Engineers Comments Regarding Surface Water Drainage

Application Reference:	AB/122/25/OUT	Reviewer Reference:	ADC/SB
Planning Officer:	Harry Chalk	Date of Review:	25/11/2025
Site Name:	Land at London Road and Land West of and adjoining Anne Howard Gardens Arundel		
Application Description:	Outline application with all matters reserved except access for the erection of up to 6 No dwellings with associated access, parking and landscaping. This application may affect the setting of listed buildings, may affect the character and appearance of the Arundel Conservation Area and is a Departure from the Development Plan.		
Assessment Number:	1 of 1

- Flood Risk Assessment, reference 13686, first issue, dated 25 June 2025. Referred to as the **FRA**.
- PROPOSED SITE PLAN 693580_205C
- Design and Access Statement, reference 718406, planning issue, dated 15 September 2025.

Proposed Site Layout & SuDS Drainage Strategy Layout

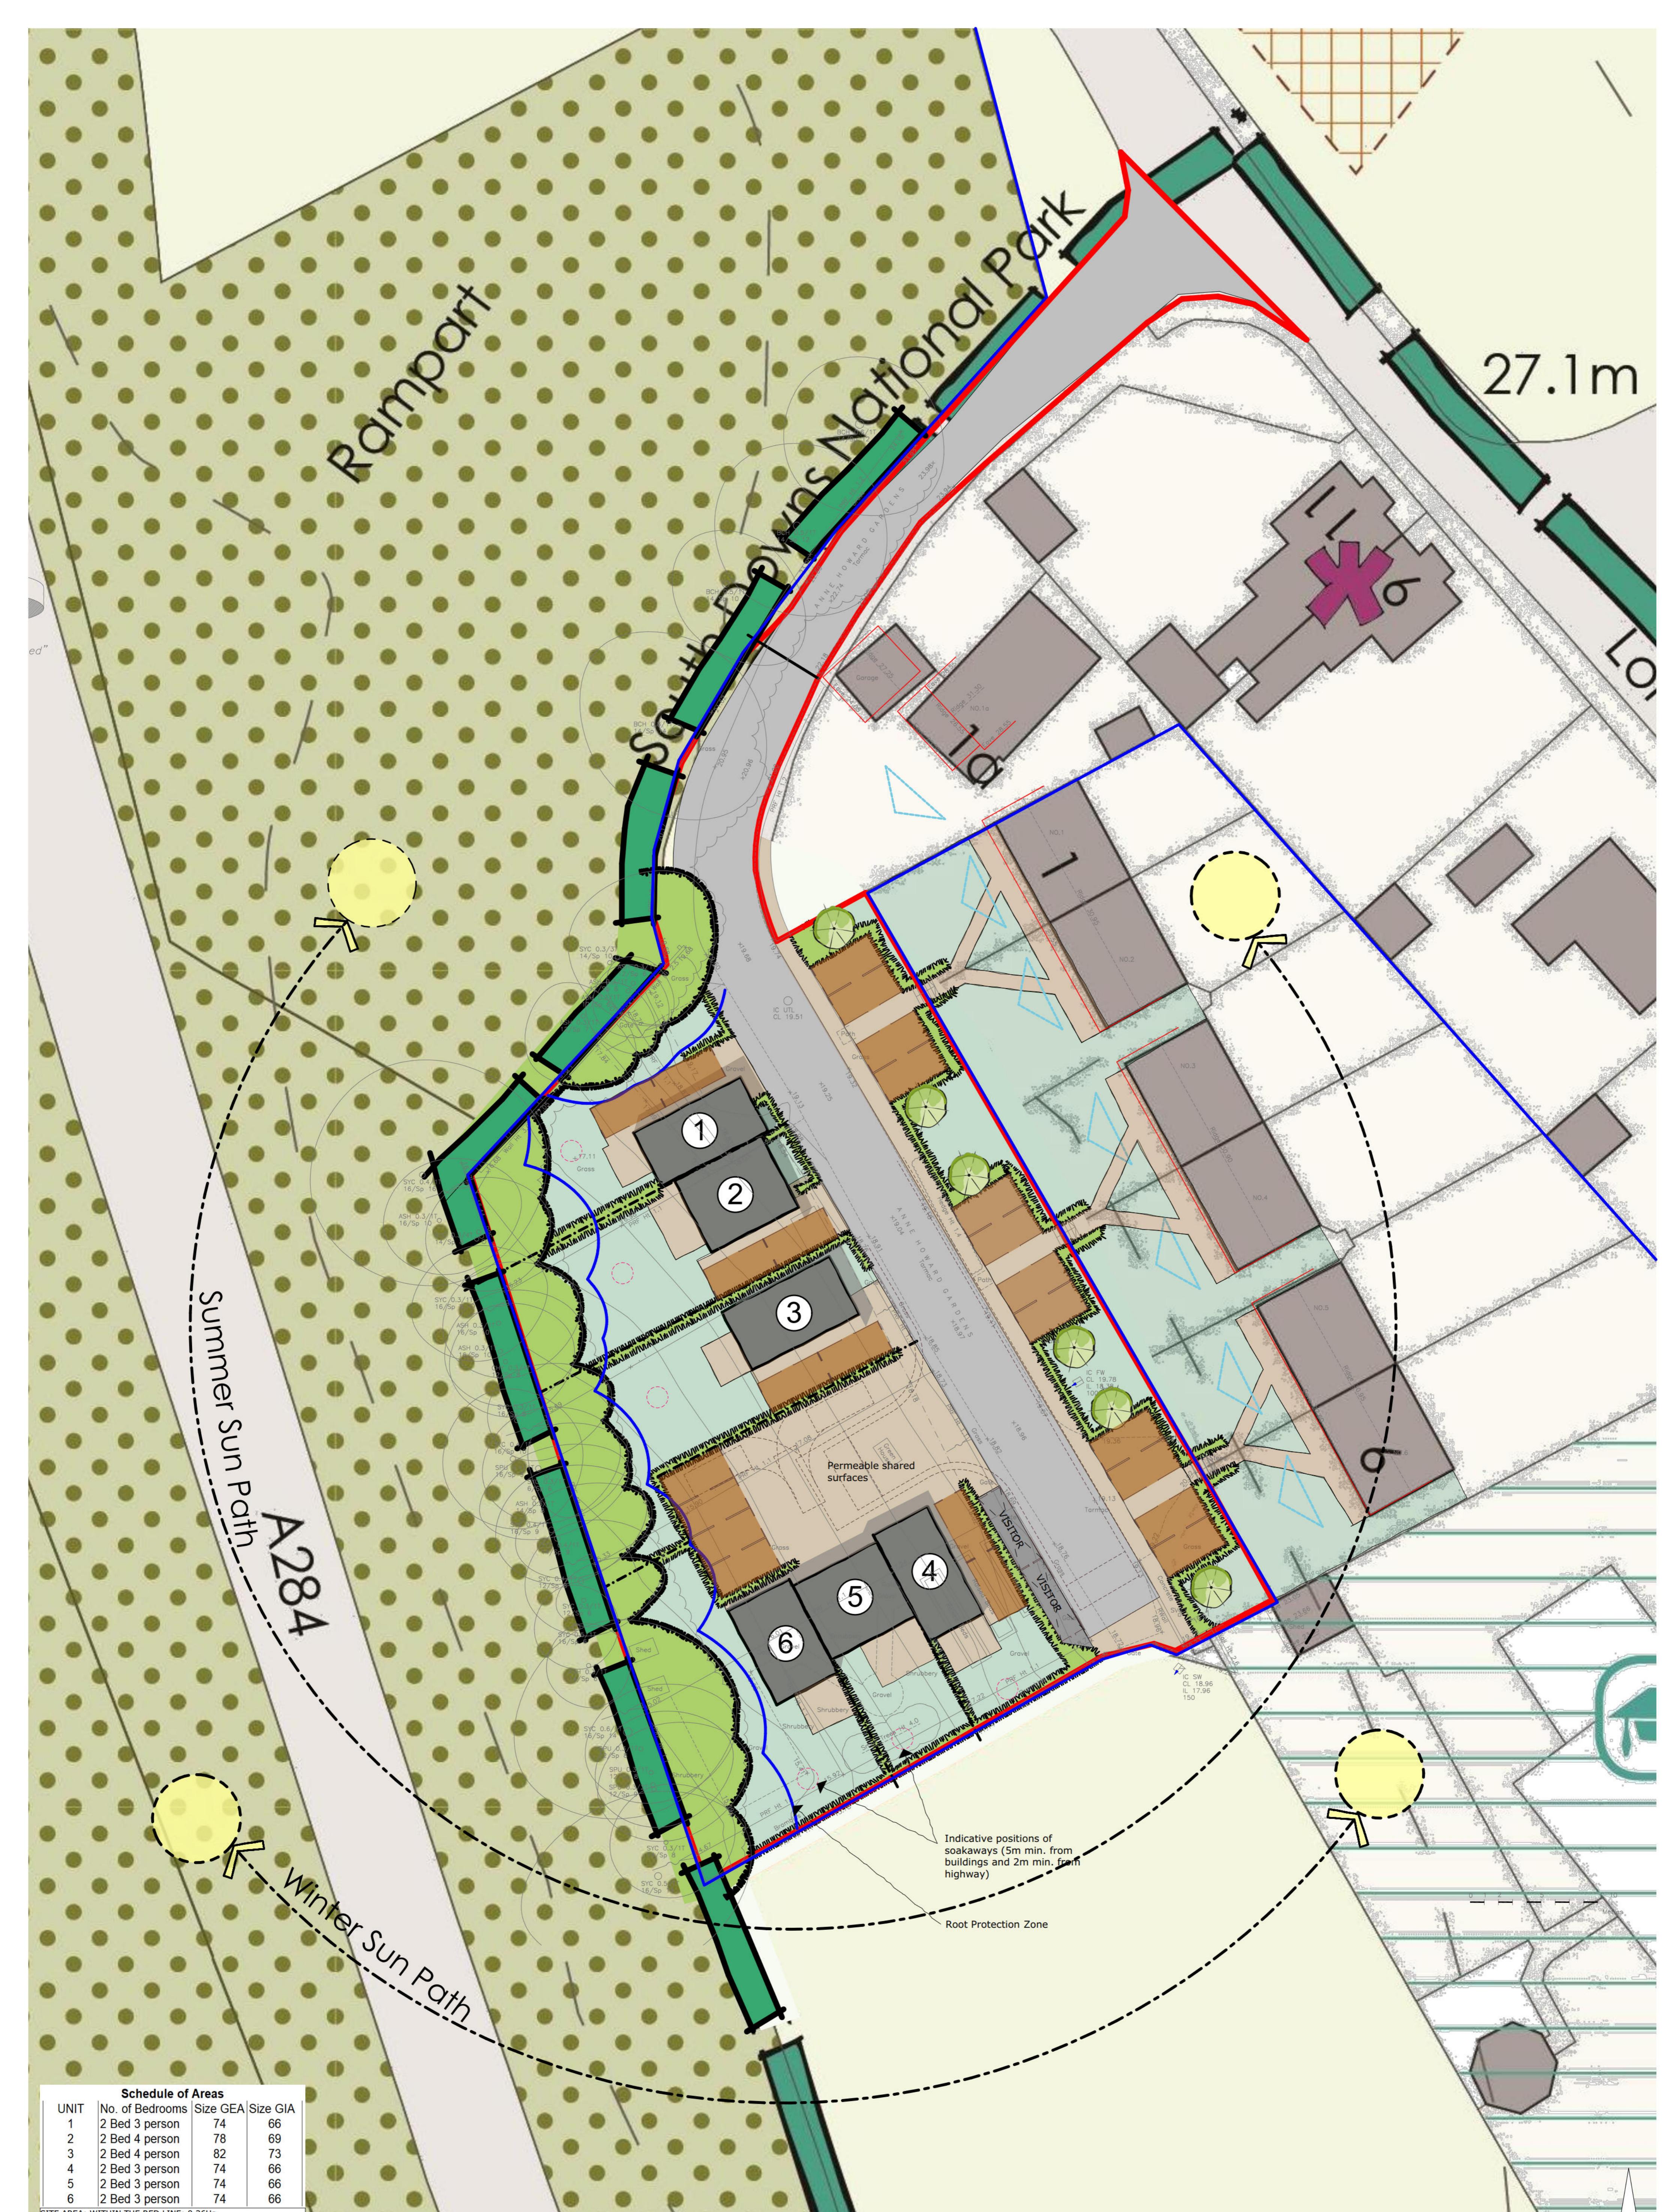
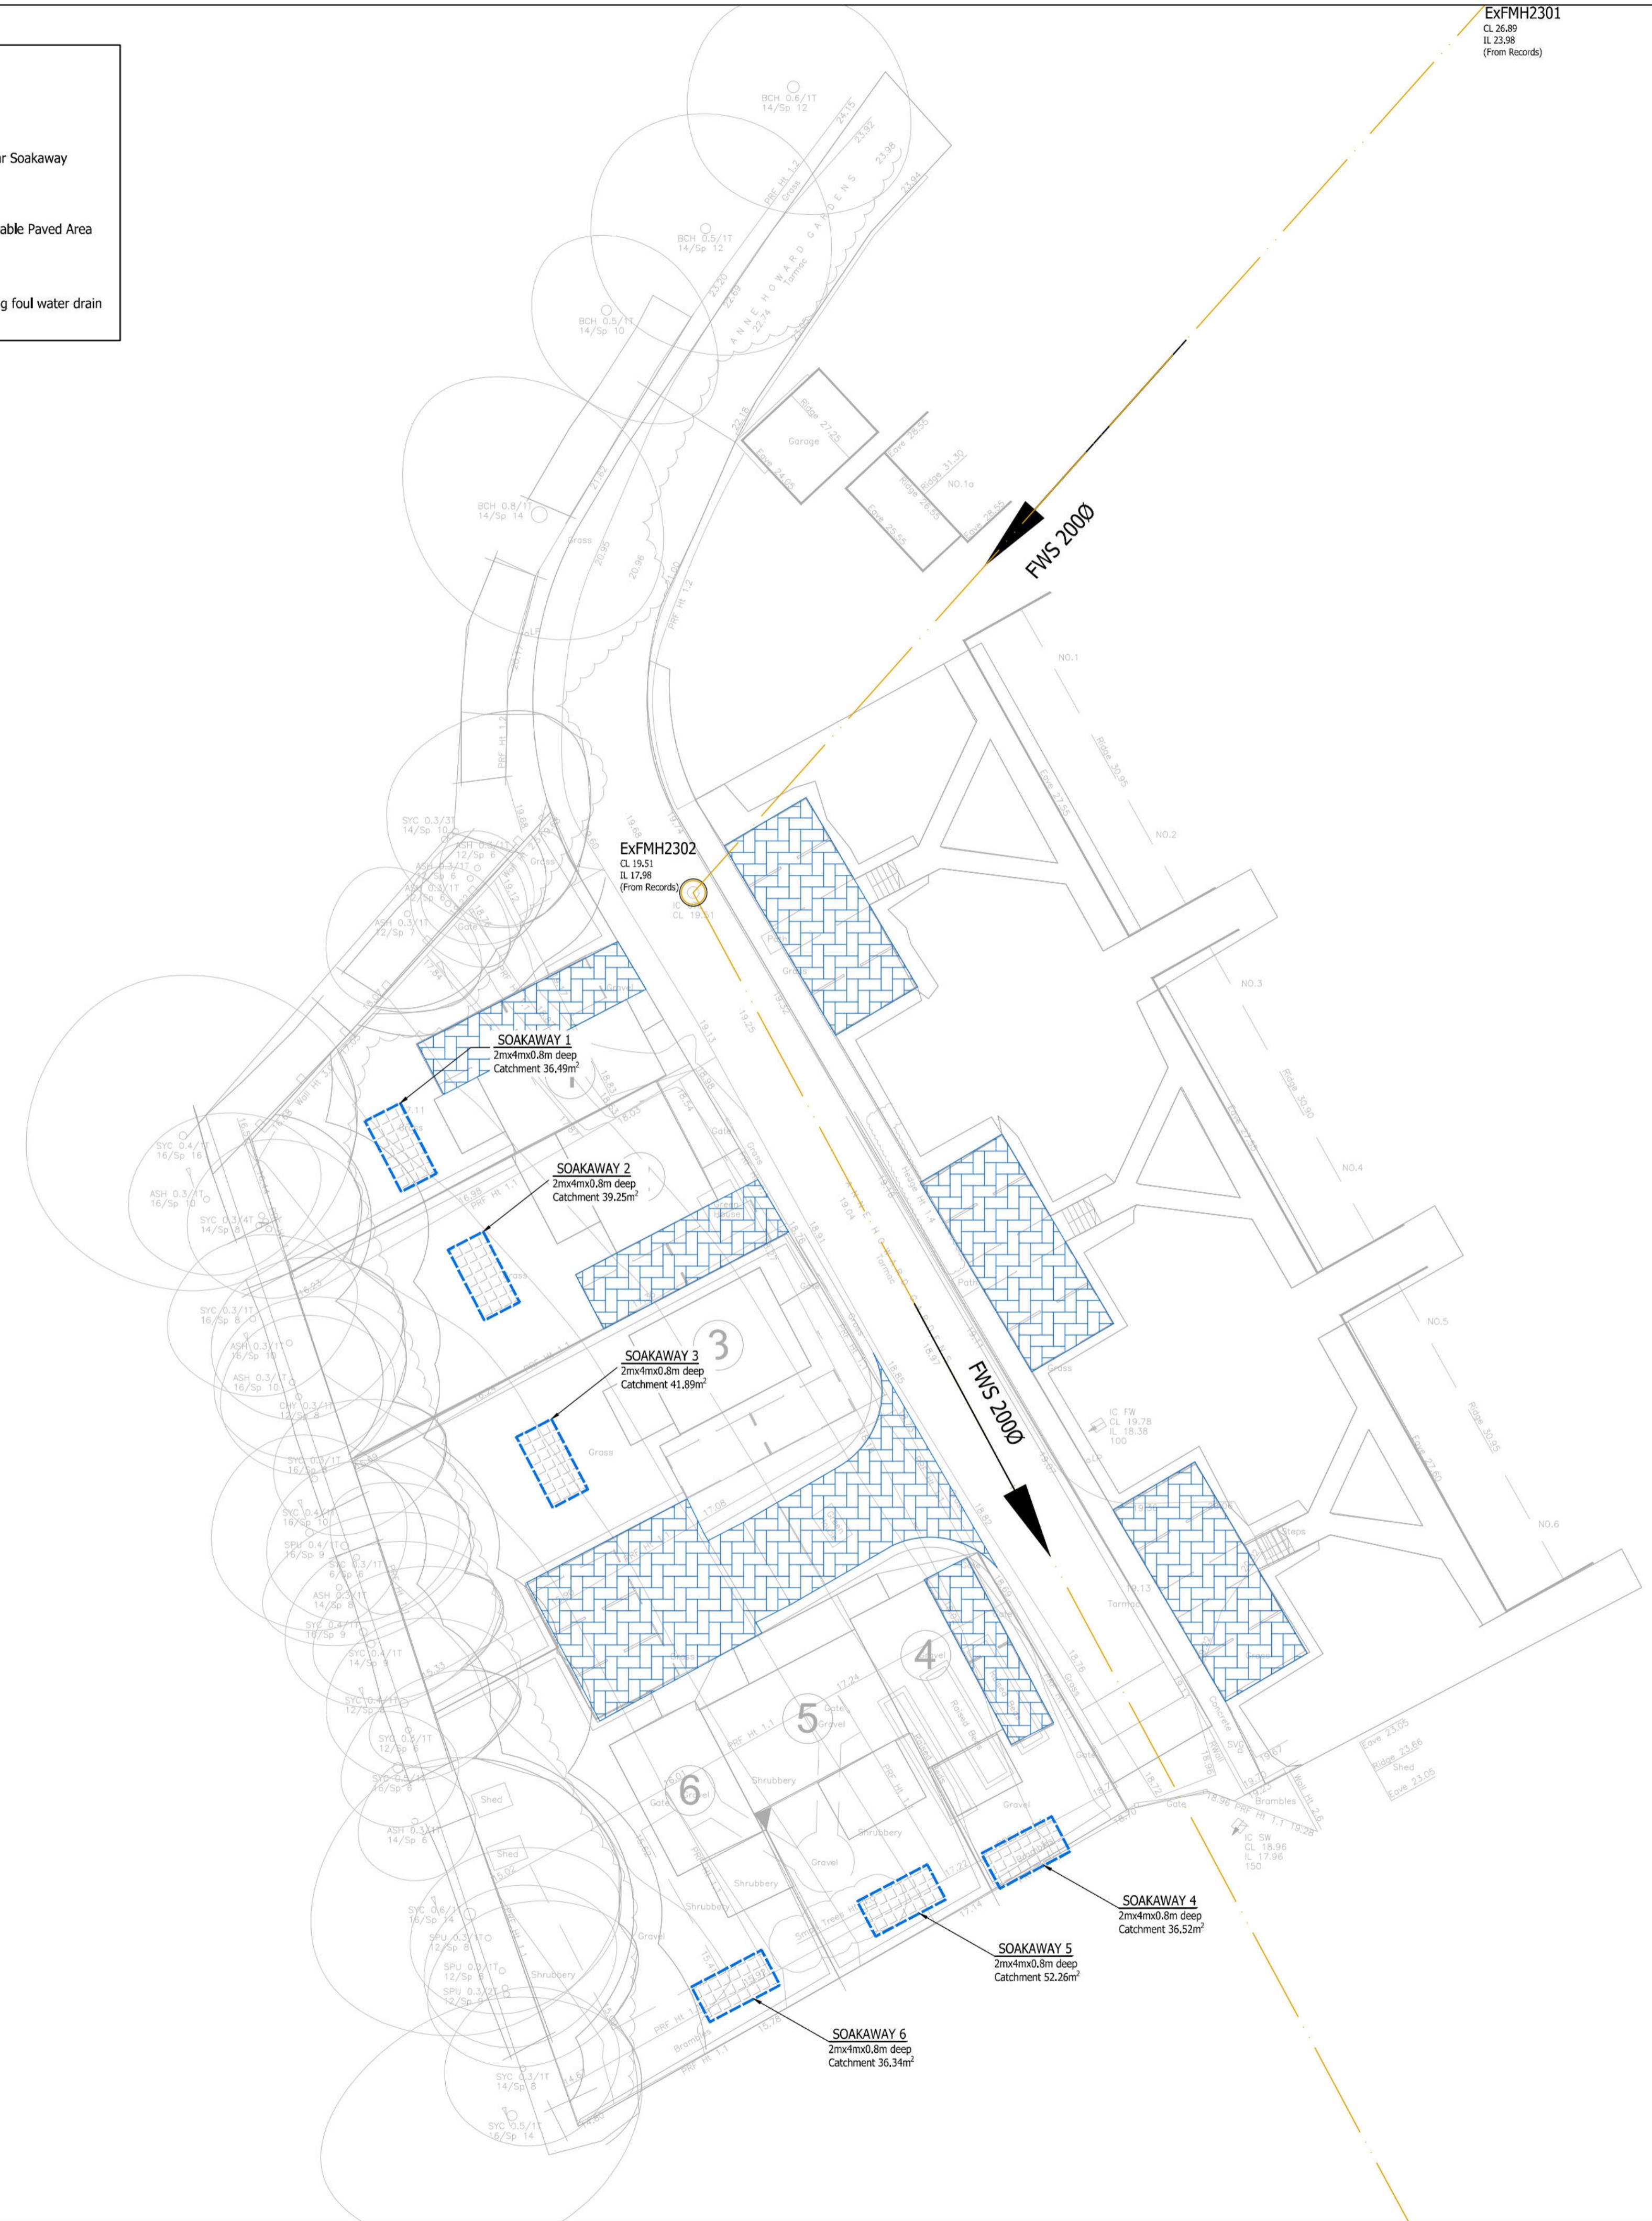
- 3.2. It is understood that the scale and layout of the development are not determined by this outline application. However, a preliminary layout and drainage layout have been submitted for assessment. It is assumed that these are submitted to offer comfort that the proposed quantum of development is achievable. However, the supporting SuDS calculations (in appendix F of the FRA) need to be revised to comply with national standards for SuDS and our guidance. Revisions include:

- Submitting the simulation settings for all features (only plot 1 submitted),

- Using a CV value of 1 for all soakaways (both summer and winter storms),
- Applying the design infiltration rate to the sides of soakaways only.
- Applying the design infiltration rate to the base of permeable paving only – once calculations and supporting ground investigations are submitted for this.

3.3. Once revised, **the storage needed for surface water may increase**. This is a heavily constrained site, due to the neighbouring property, slopes and existing trees. Therefore, it is unclear where additional storage may be provided. Indeed, the submitted drainage layout already shows the soakaways for plots 4 to 6 very close to the southern boundary which does not represent best practice. If these soakaways must increase in size, it is unclear where they can be accommodated.
